RE: Starbucks at 4601 Wyoming Blvd NE
Grading and Drainage Plan
Engineer's Stamp Date 2-1-2017 (File: F19D013C)

the design COLLECTIVE

Project #:BP-2016-32291 (File: F19D013C) Case #: 16DRB-70420 and 16EPC-40040
City Engineer's comments dated January 24, 2017 (attached)

SHEET NUMBER:
C-0010

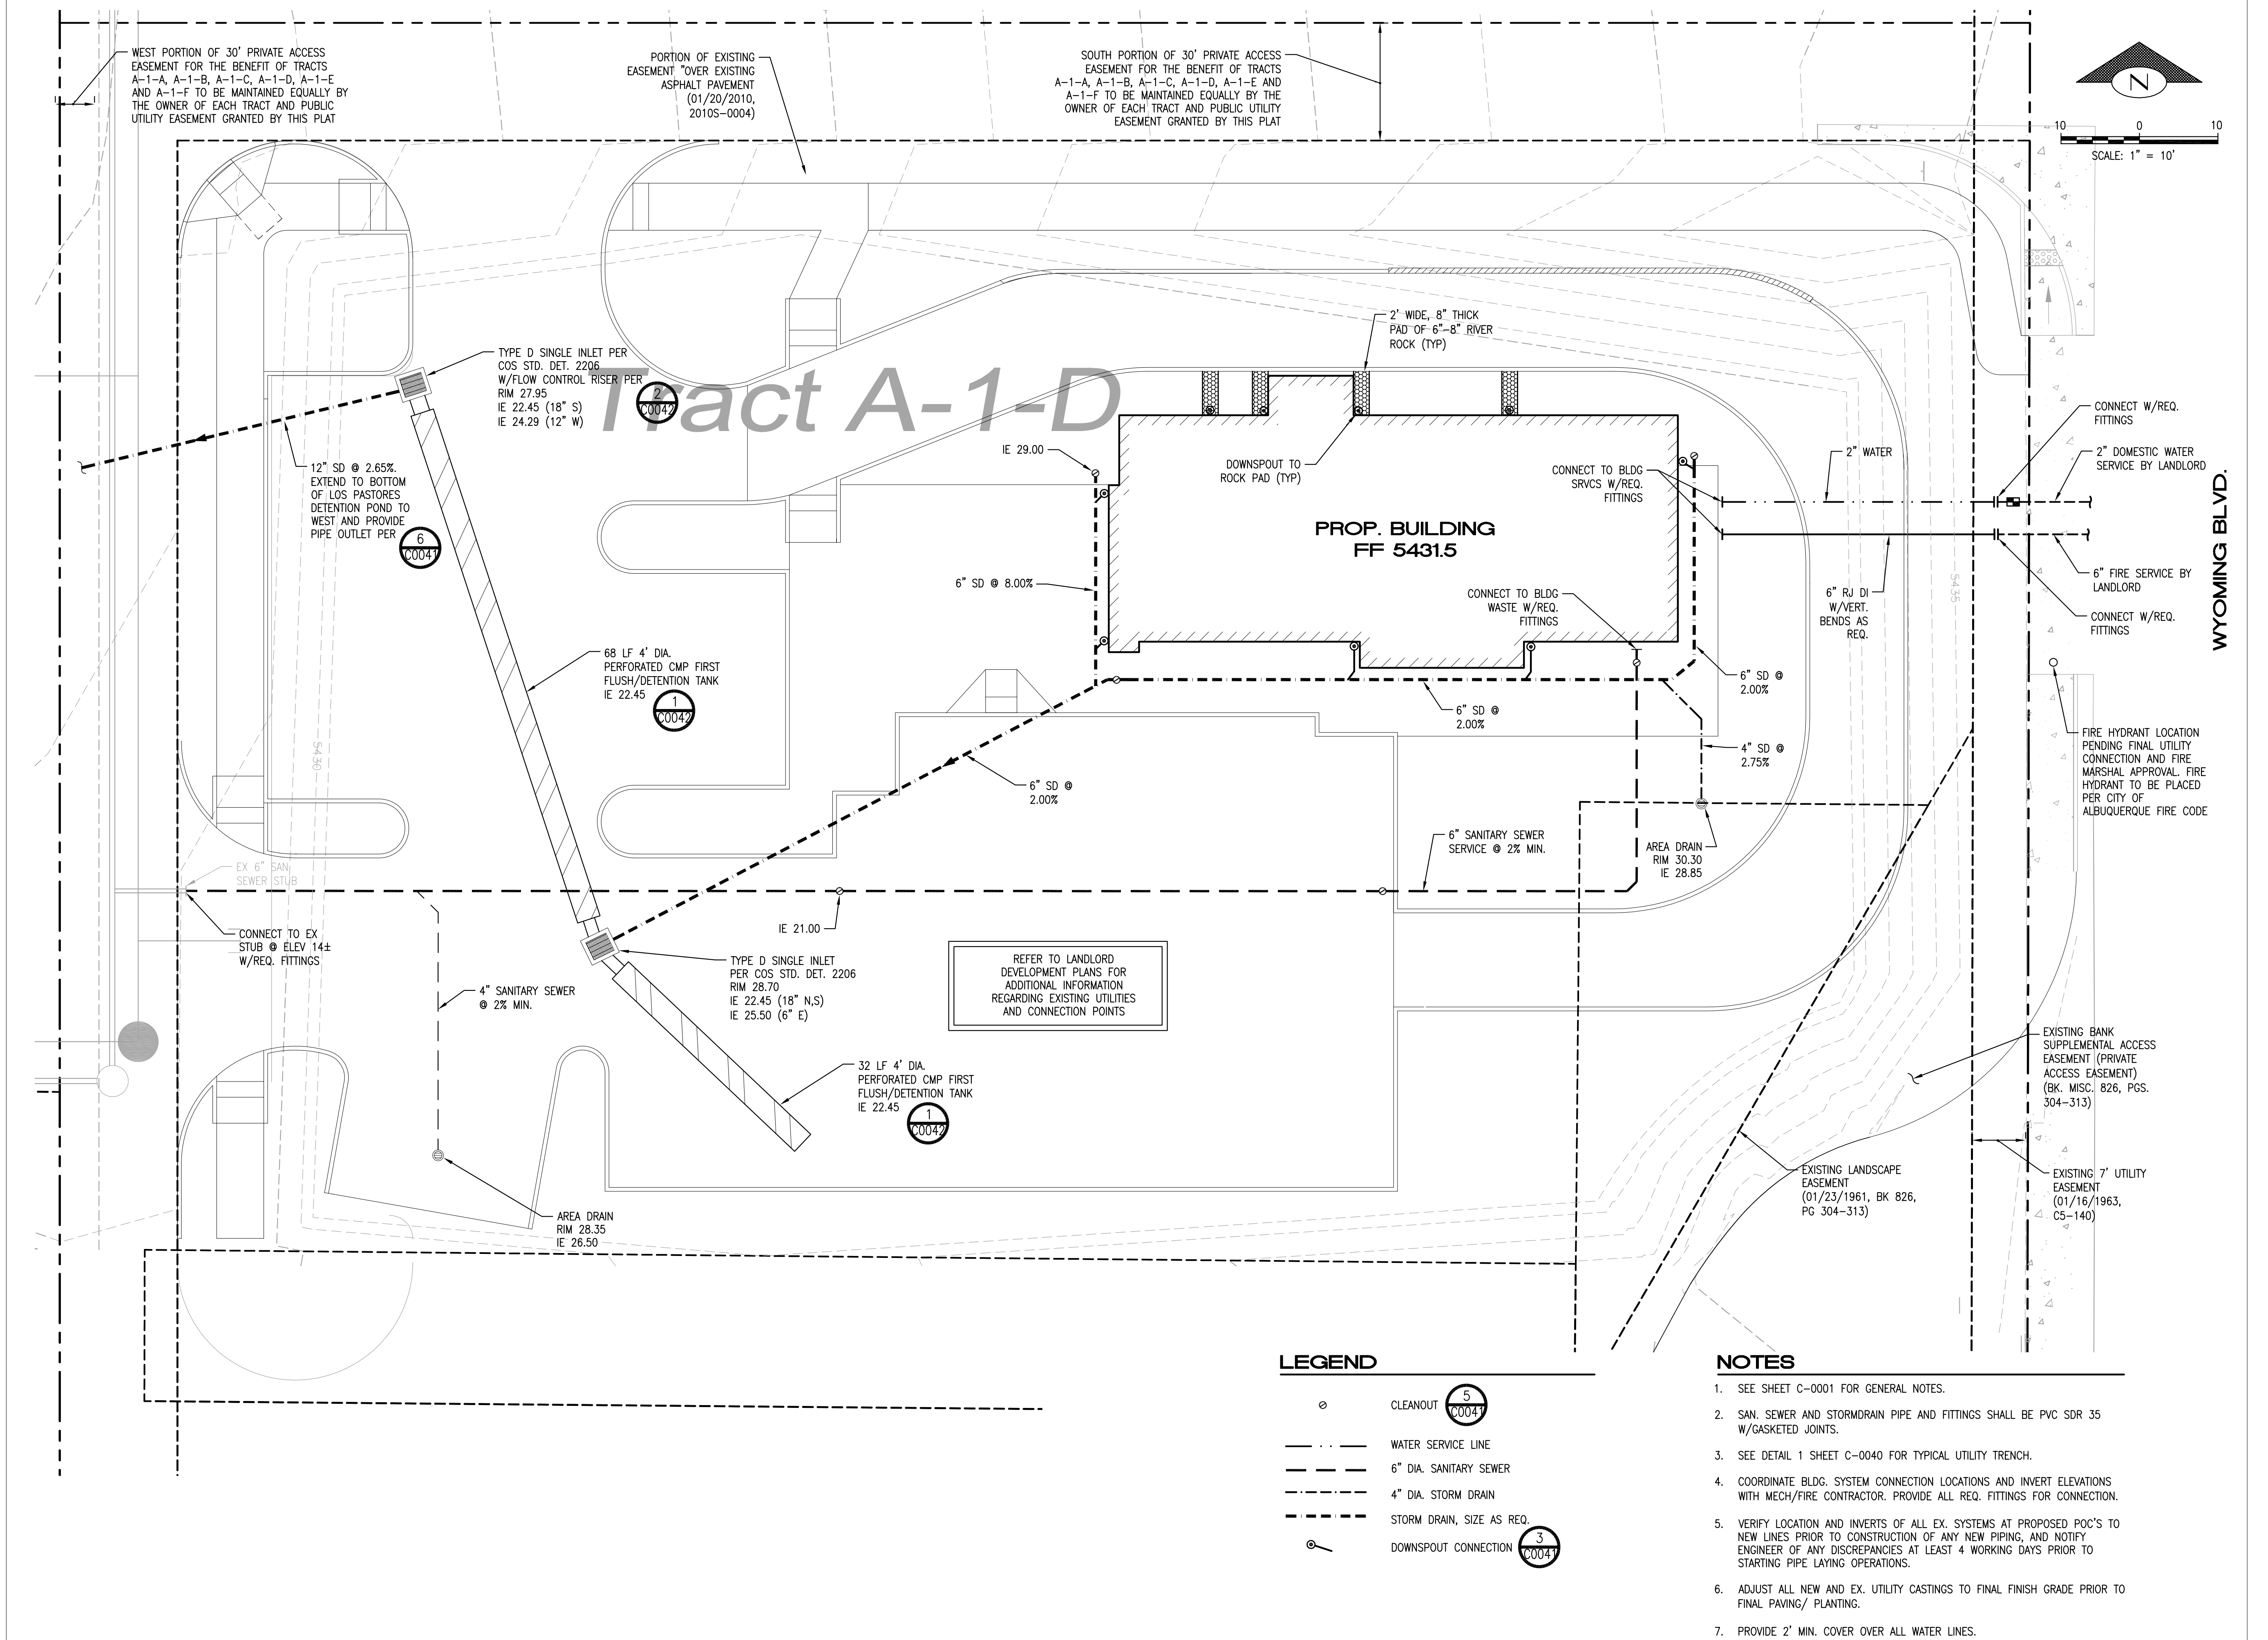
Show the entire stretch of the 12 inches storm drain to the pond including grades, inverts and other utility crossing. Provide easement document across the adjacent property. Who will maintain the pond?

Trash enclosure drain must drains to grease trap then to SAS.

Provide inverts for the 4 feet Dia. CMP.

Full pipe run is shown on revised plans. Invert information at sewer crossing has been added.

Oil/Grease Separator has been added as requested to revised C-0010 and detail 3/C-0042 sheets.

Inverts are indicated on the callout note for each section of CMP. Refer to revised sheet C-0010.

C-0042

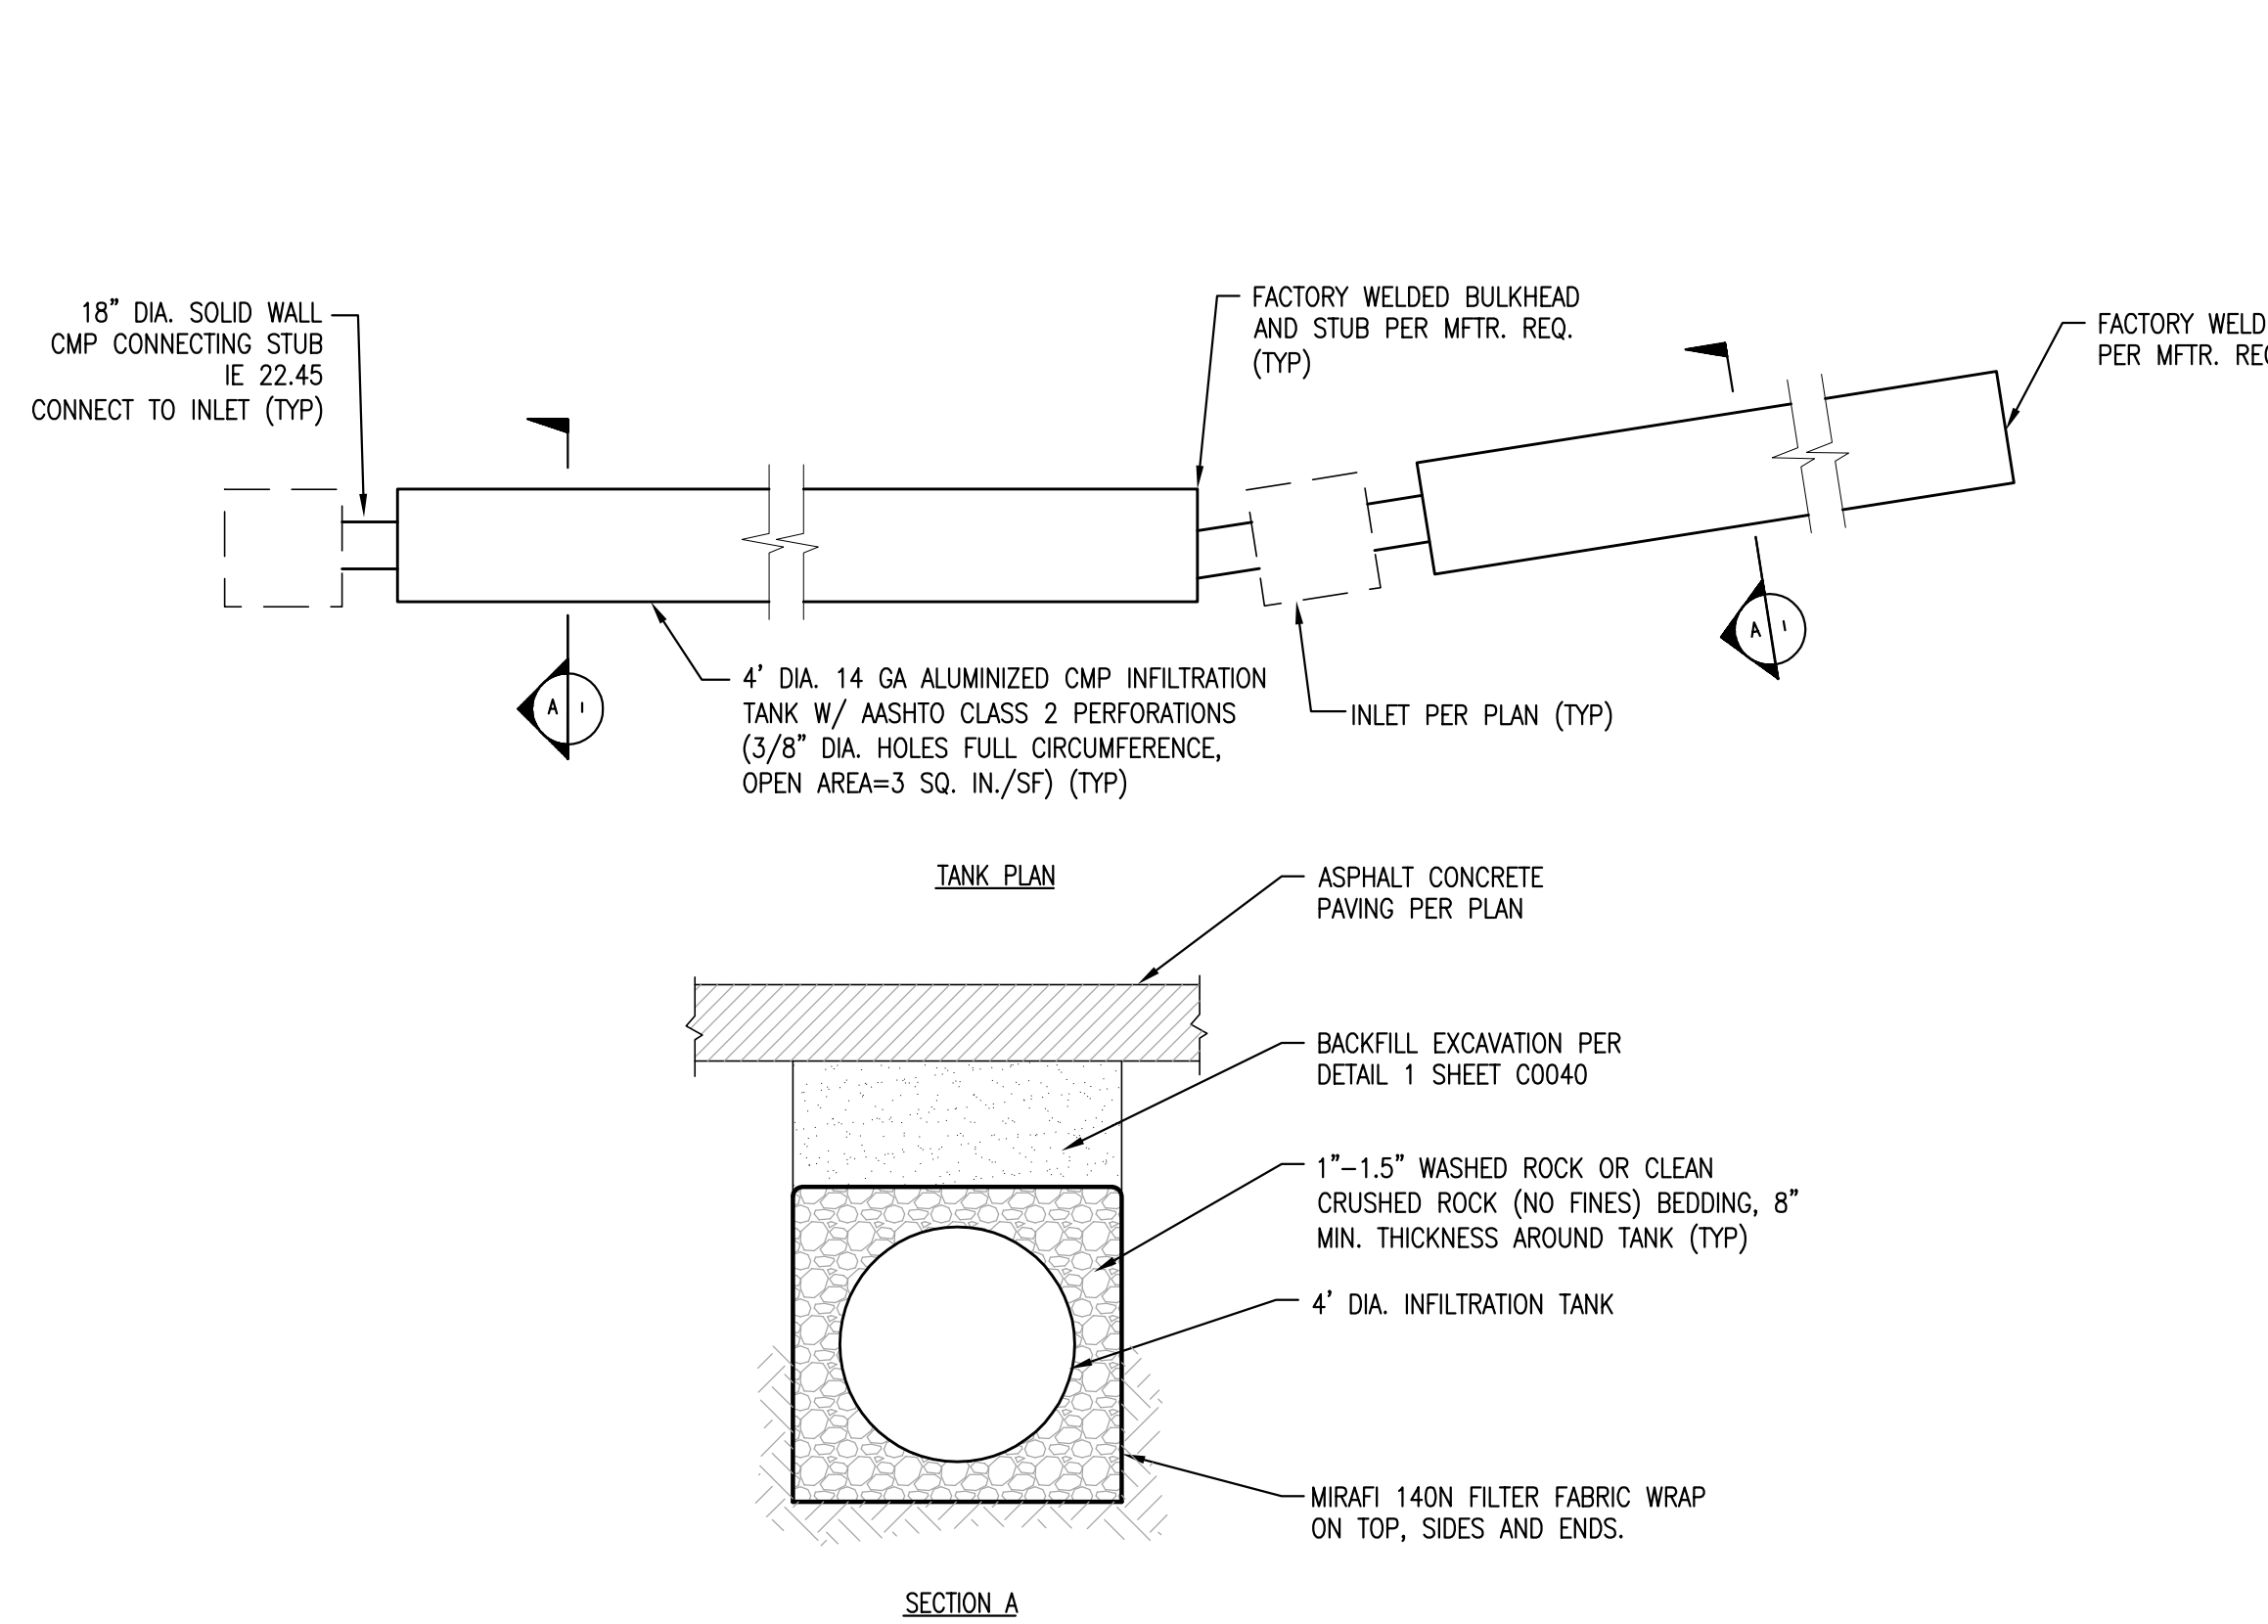
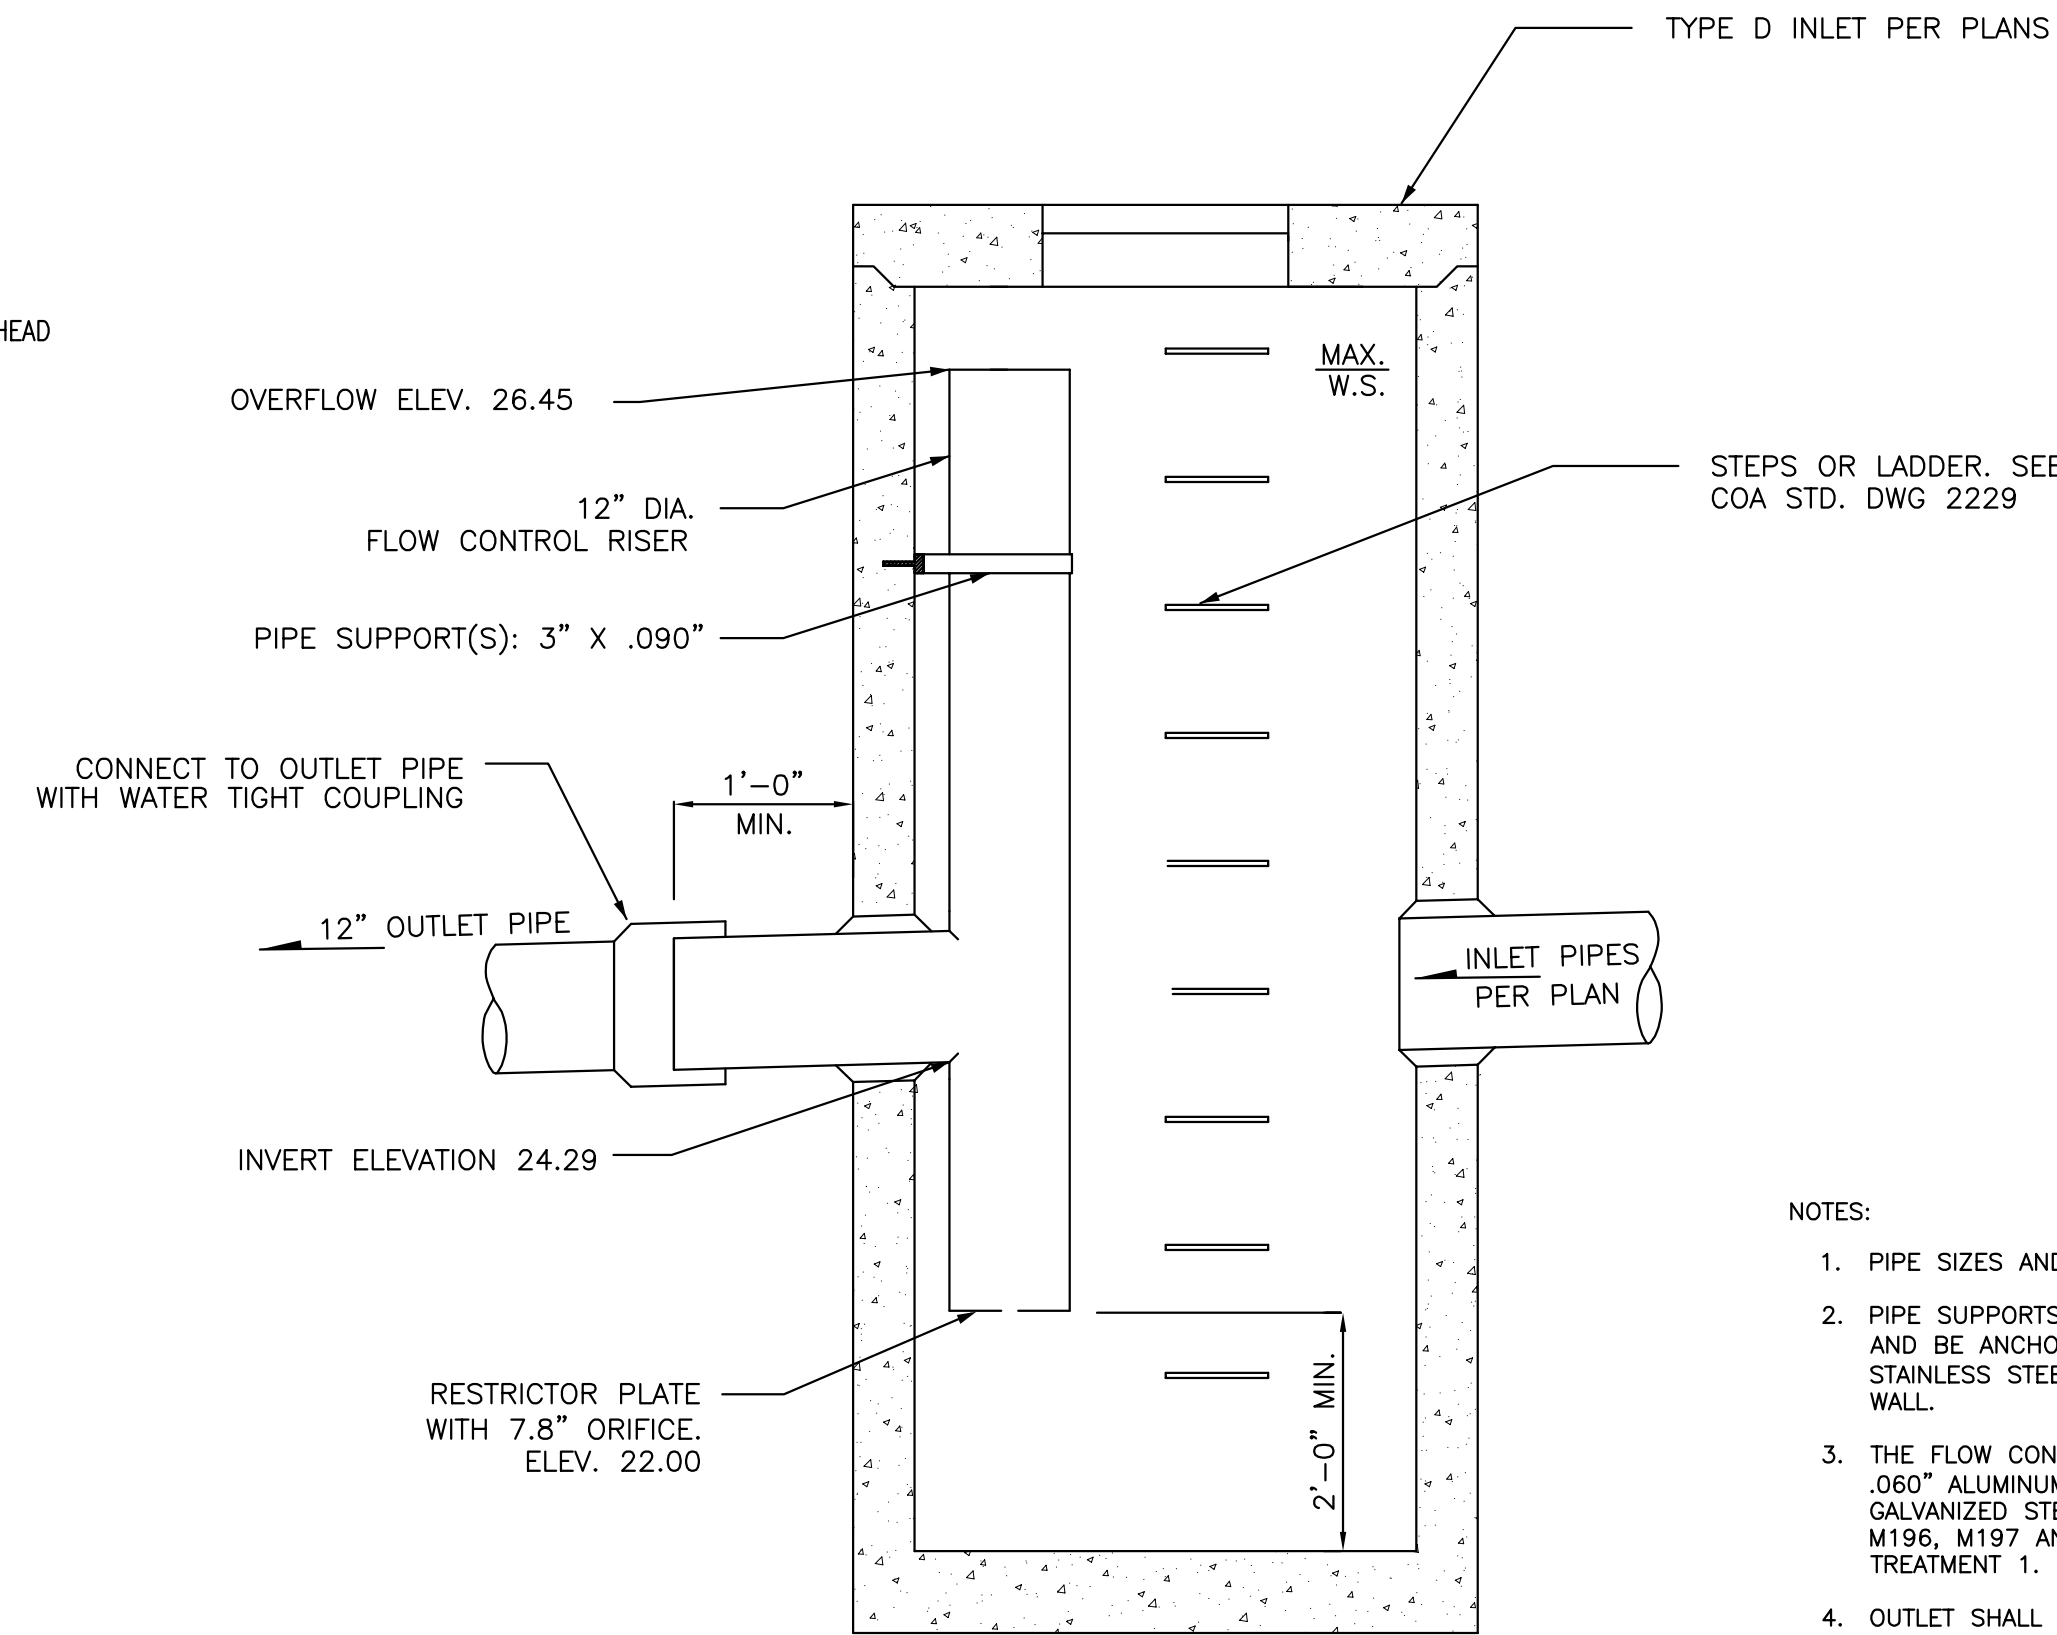
We recommend to use COA modified grate detail include a copy with this plan with your next submittal.

Grate has been modified as requested and Std. Detail has been added to revised sheet C-0042.
